# Memo

**Subject:** Dunloe Park Sand Quarry

**Reference:** MP 06\_0030 MOD 2

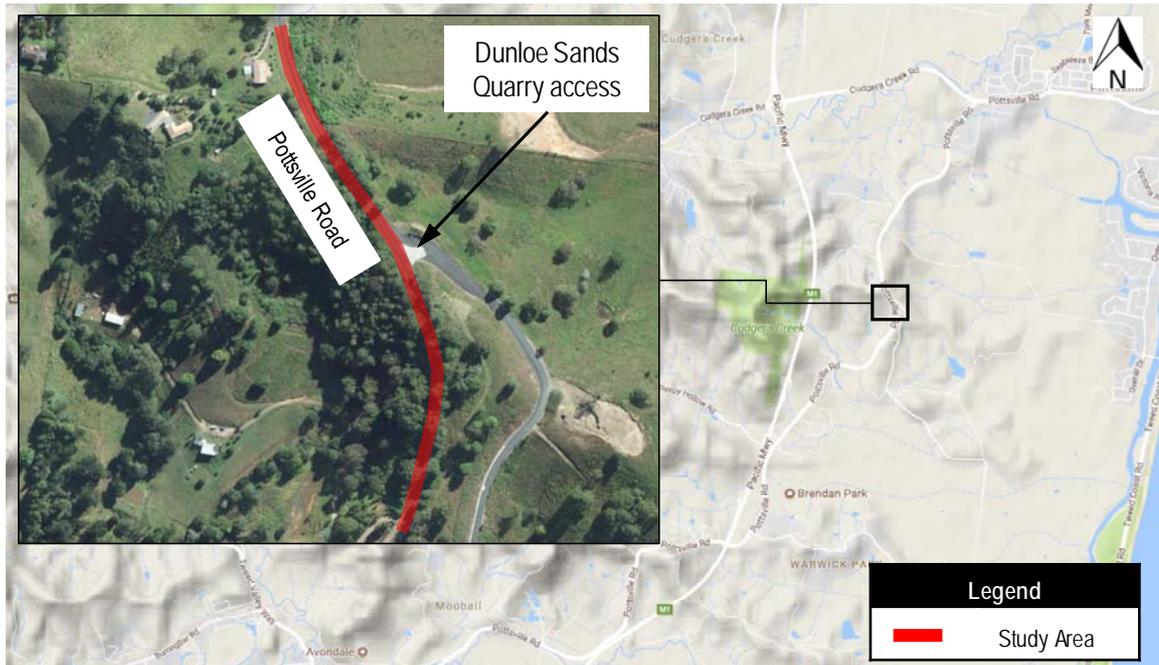
The Dunloe Sands Quarry currently has provision of private access in the form of a priority controlled T-intersection with Pottsville Road. This intersection is located on the elevated section of Pottsville Road with a posted speed of 80km/h and provides a sealed and concrete surface.

The Austroads prescribed requirement is 228m SISD (based on 80km/h posted speed and 6% downgrade). The existing intersection formation has provision of approximately 130m driver sight distance to / from the south and 160m to / from the north approach. The deficiency in sight distance needs to be addressed further by the applicant and any remedial works to address the deficiency should be identified.
